February 6, 2023

County File: ANX231

Re: Town of Monument Annexation - Beacon Lite LLC

BEACON LITE LLC
ANNEXATION PLAT

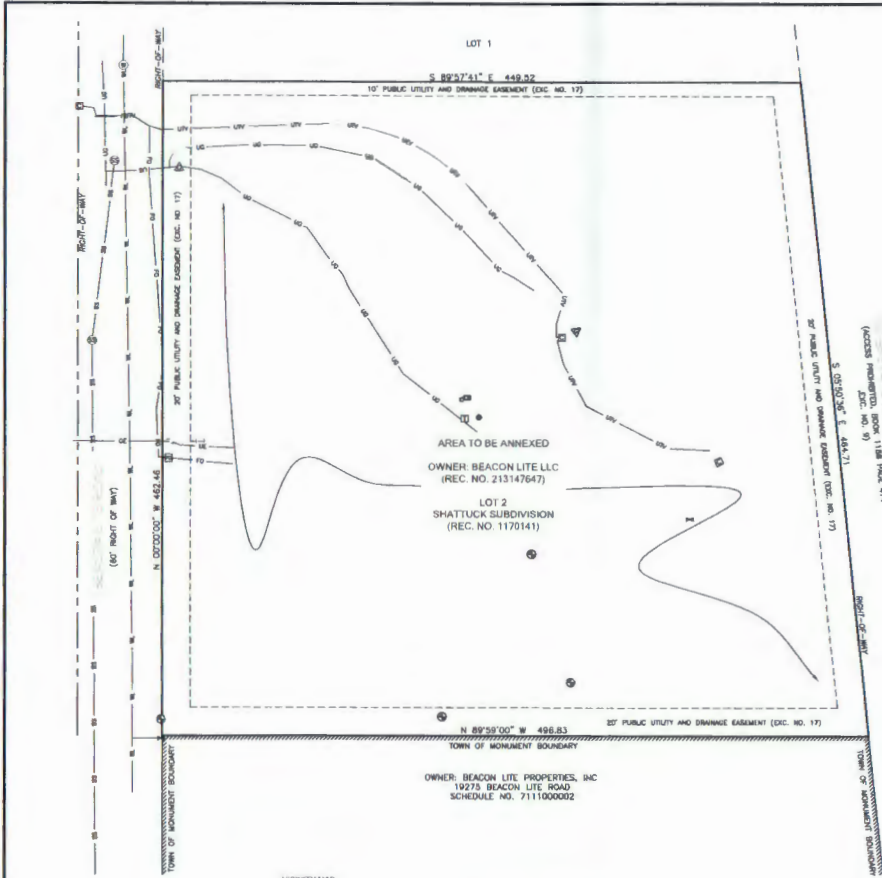
1. El Paso County requests the Town of Monument annex Beacon Lite Road from 1358' north of Highway 105 to Wakonda Way. See the attached exhibit.
2. Right-of-way dedication is required with future platting of the property if Beacon Lite Road remains within Unincorporated El Paso County ownership/maintenance at the time of application.
3. Future site development of the property will require a driveway permit from El Paso County if Beacon Lite Road remains within Unincorporated El Paso County ownership/maintenance at the time of application.
